AB/13/09/**PLANNING APPLICATION REPORT****REF NO:** AB/13/09/**LOCATION:** Land Adjacent To
1 Anne Howard Gardens
Arundel**PROPOSAL:** Proposed 3 bedroom dwelling (resubmission of planning application AB/68/06)**SITE AND SURROUNDINGS**

DESCRIPTION OF APPLICATION	Proposal is for a detached 3 bedroom dwelling with a two and a half storey height. A bedroom and en suite would be provided in the roof area.
SITE AREA	.03 hectares
RESIDENTIAL DEVELOPMENT DEN	33 dwellings per hectare
TOPOGRAPHY	Land slopes steeply to A29
TREES	None of any significance affected by the proposed development.
BOUNDARY TREATMENT	2m high brick wall to road side. Front gardens open except of low hedging.
SITE CHARACTERISTICS	Anne Howard Gardens semi-detached two storey houses. Brick elevations. Plain tile roof. No windows in side elevation of last house. Currently garden area to no. 1. Parking space on road to side. Existing gap in wall adjacent to gravelled parking area. No dormer windows in Anne Howard Gardens at present.
CHARACTER OF LOCALITY	Predominantly residential characterised by detached and semi detached dwellings of varying design.

PROPOSED NORTH EAST ELEVATION
SCALE 1:100

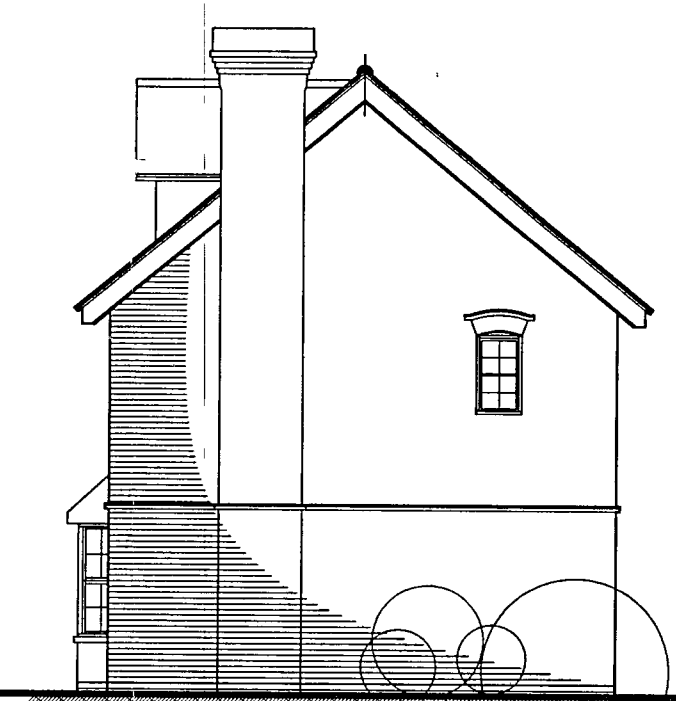
It is agreed that the window at second floor level in the north west elevation and velux in the north east elevation should be obscure glazed to prevent any adverse overlooking. Access is existing.

It is considered these changes are acceptable. Windows have been added in the roof, but it is proposed to control those on the north west and north east elevations, be obscure glazed to prevent any material loss of privacy. The bulk and position of the building is largely as previously approved.
